Application by Port of Tilbury London Limited for an Order Granting Development Consent for a Proposed Port Terminal at the Former Tilbury Power Station ('Tilbury2')

Amazon UK Services Interested Party Reference: TIL2-AFP0005

Traffic Impact at Asda Roundabout

Drawing Title: **GENERAL ARRANGEMENT PLANS ASDA ROUNDABOUT SHEET 5 OF 5 REGULATION 5(2)(o)**

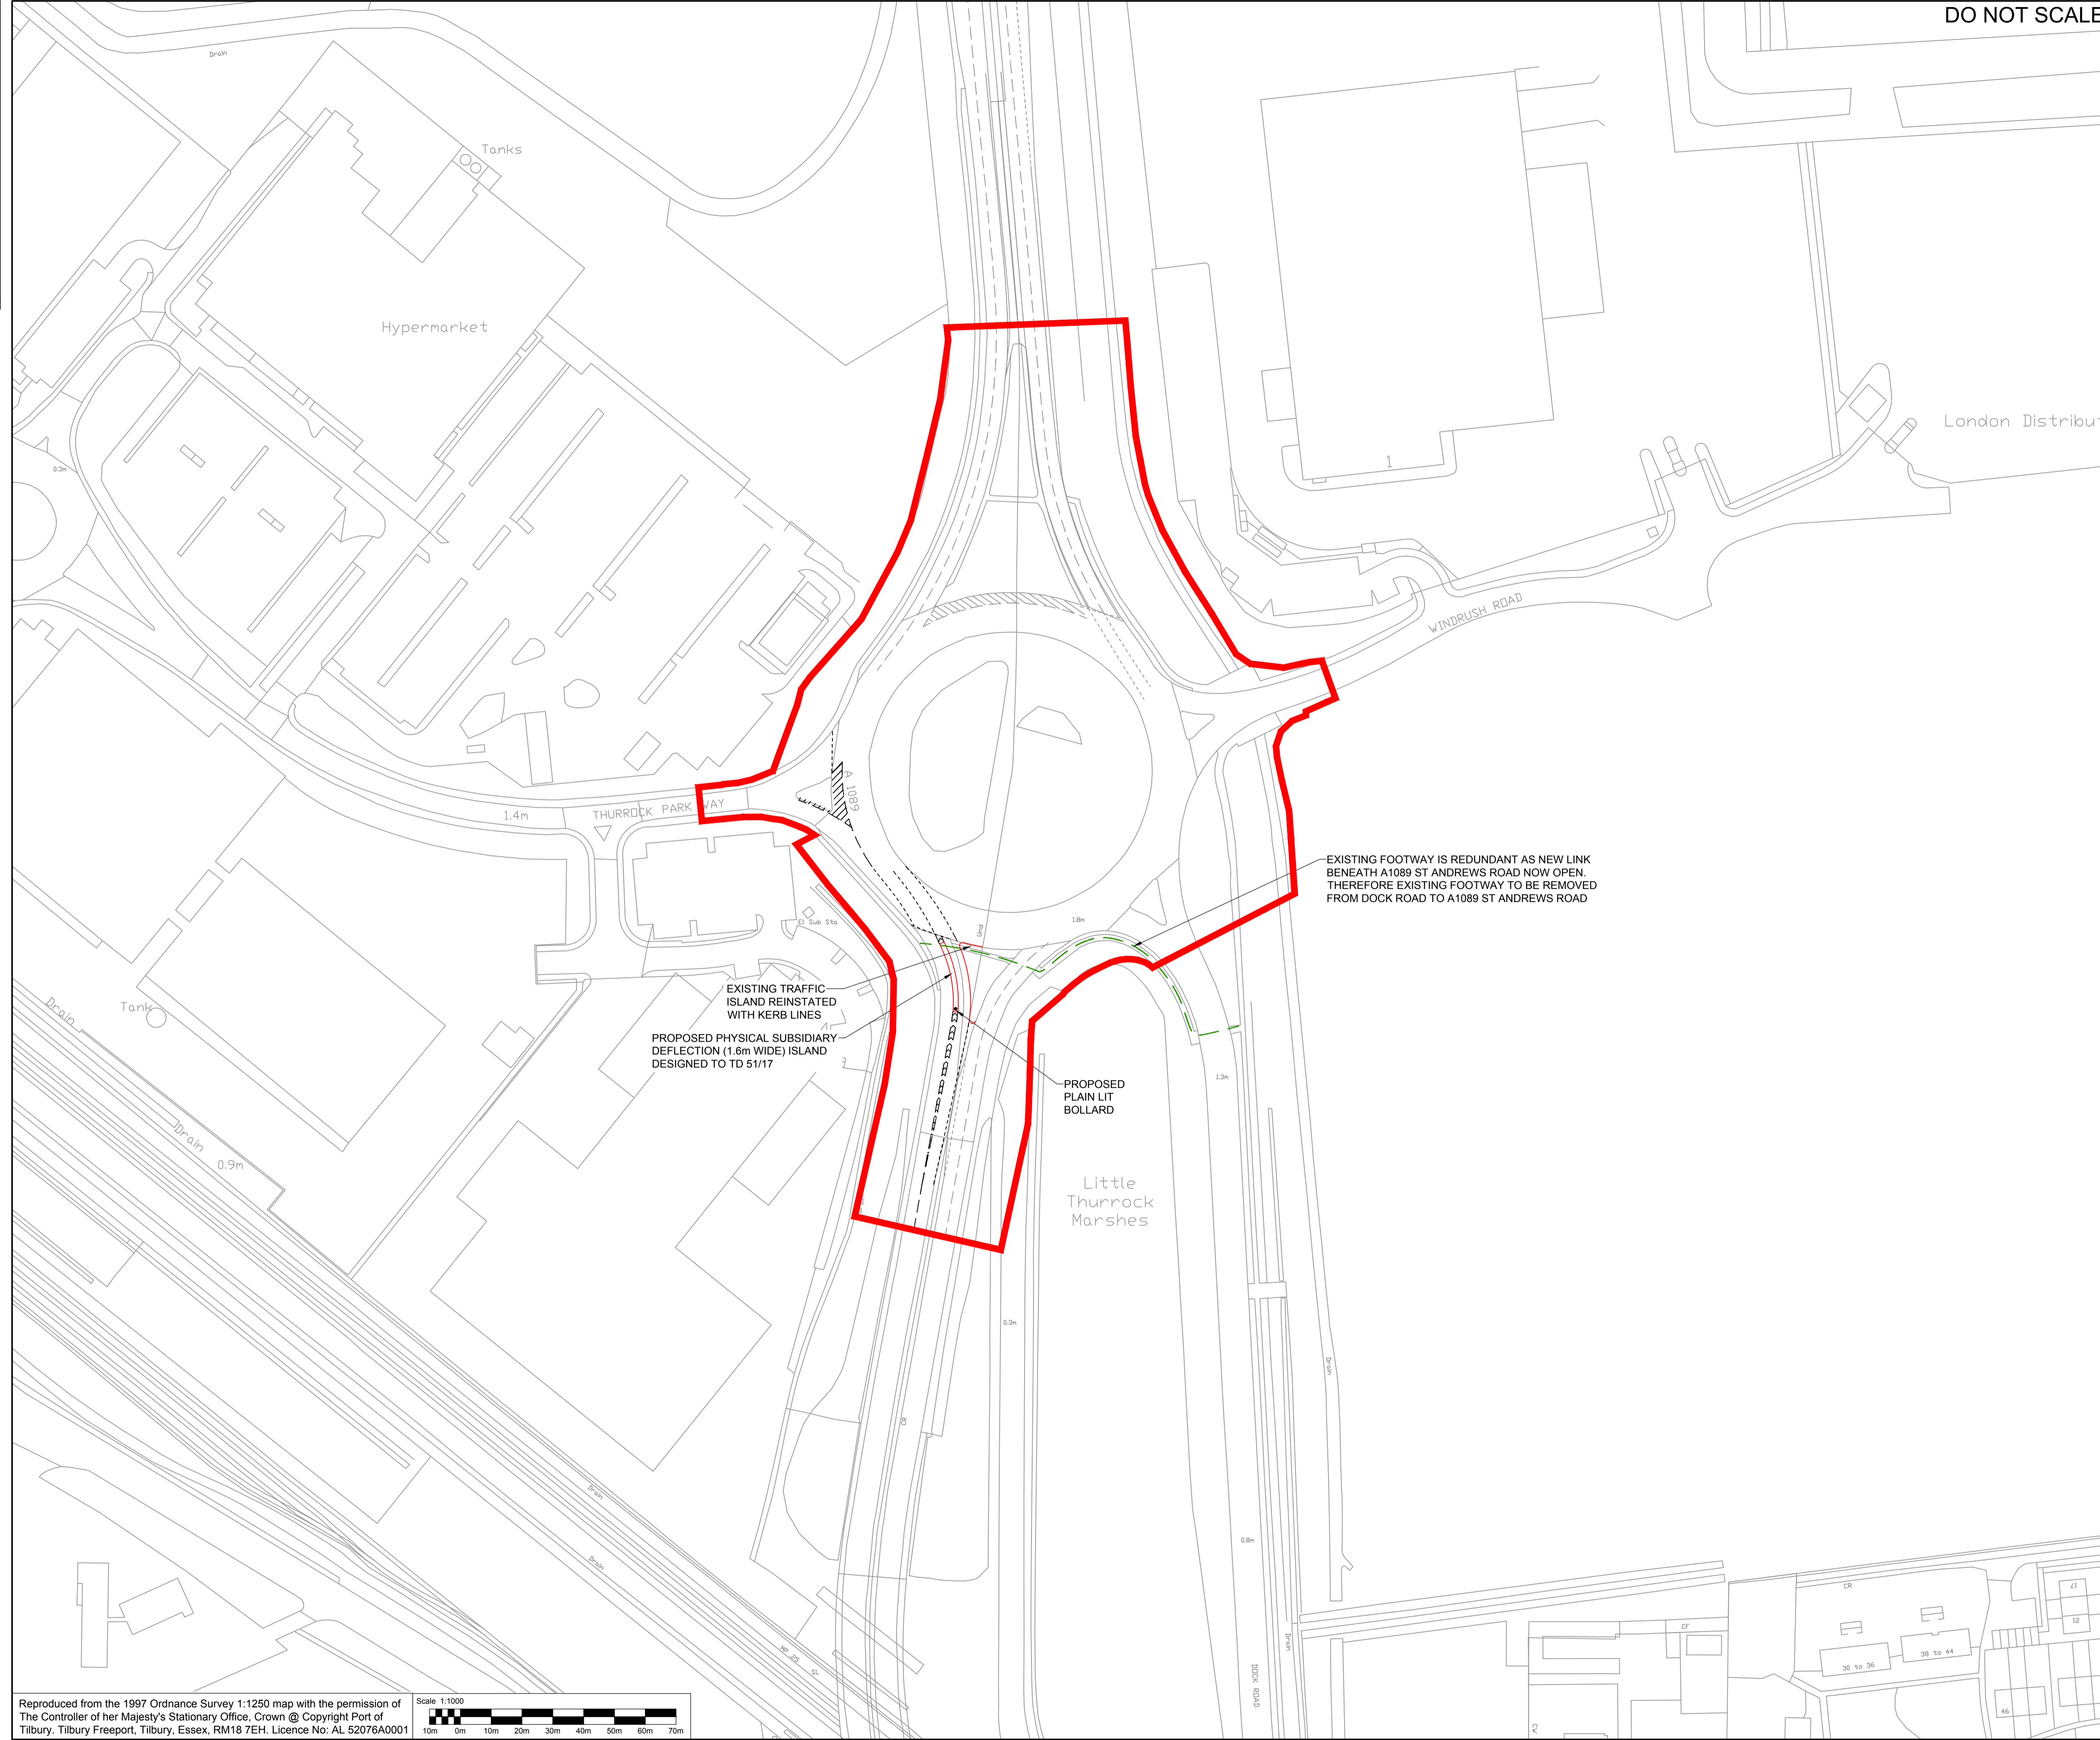
We can confirm that the only remaining transport/traffic concern with regards the Tilbury2 proposals relates to the operation of the Asda roundabout. In summary:

- we are not satisfied that the permitted level of Amazon traffic has been considered in the iTransport traffic modelling;
- the 07.00-08.00 morning peak period assessed indicates that queues would significantly increase on the A1089 Dock Road approach to the roundabout;
- the 18.00-19.00 evening peak period assessed indicates that queues would increase on the Thurrock Park Way approach to the roundabout; as a result
- a query remains over the proposed mitigation measures put forward, particularly to address the morning peak period impact, as no mitigation works on the A1089 Dock Road approach have been put forward to date.

The information provided has confirmed that the traffic modelling still does not include the full permitted traffic generation of the Amazon site. The modelling also assumes that much of the Amazon staff traffic would travel to and from the Amazon site via the London Distribution Park HGV access and not Dock Road and the car park entrance to the Amazon site. This alters the results of the traffic modelling.

The review of the iTransport modelling has concluded that in the 07.00-08.00 period there would be a significant increase in the queue lengths that would occur on the A1089 Dock Road approach to the junction, as a result of the addition of Tilbury2. However the PEP analysis has indicated that these results however underestimate the queues likely. As yet we have not seen any mitigation measures to address this.

Traffic modelling results from iTransport for the time period 18.00-19.00 have also underestimated the potential impact. The PEP results have indicated that whilst the impact on the A1089 Dock Road, or Dock Road arms would be limited, significant queues would build up on the Thurrock Park Way arm of the junction. This would not impact on the operation of Amazon. This is a matter for other stakeholders.

The traffic impact information for the Asda roundabout provided to date has concluded that a traffic impact would occur as a result of Tilbury2. As yet mitigation measures have not been shown to address this.
